Nicole Gaudette,  
Senior Planner  
City of Mercer Island Development Service Group

November 2, 2018

**Subject: Response to comments**

**DRAINAGE & LANDSCAPE
& BLOCK WALL PLAN**

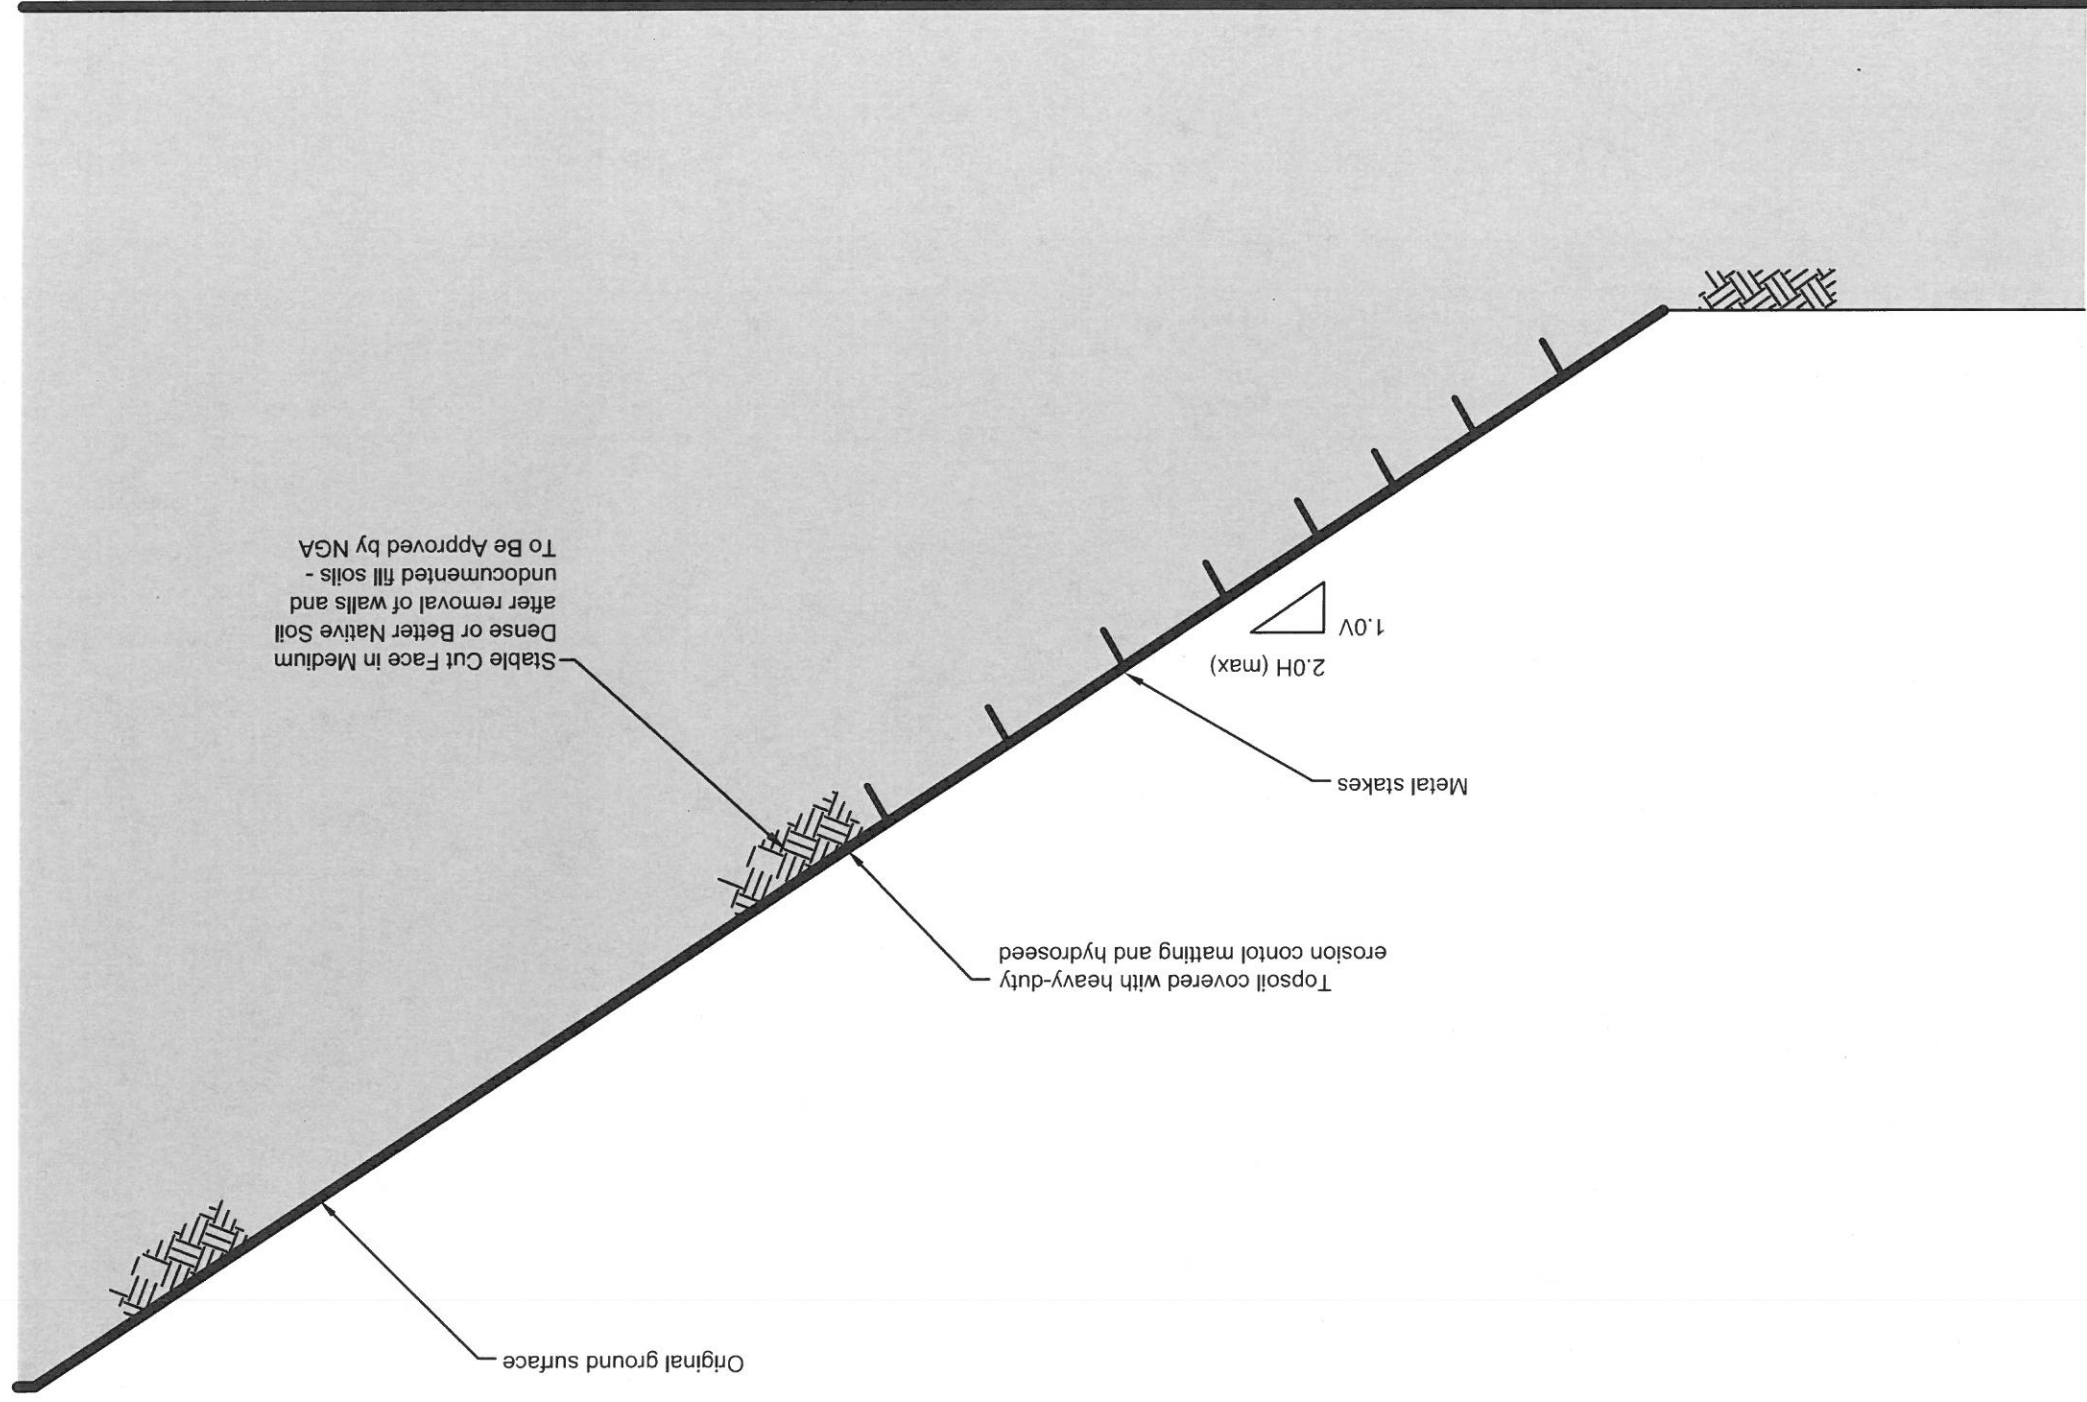
2. It appears the applicant has removed several trees within two years, either provide full analysis of timelines of work within the last two years. Or provide replanting plan in critical area with at least 4 trees to be planted and bare soil covered.

3. City trees were previously removed without permit per code compliance case CE15-0007 and it appears the mitigation plantings were removed. Show these trees replanted on replacement plan. At least 3 trees need to be replaced on the city right of way with drip irrigation. These species on city right of way shall three different species from the following list.

**Response:** Seeding will be planning on the critical area. 4 trees will be planted per city requirement.

**Reponses:** 3 trees will be planted at city right of way and the trees will be selected from the list above.
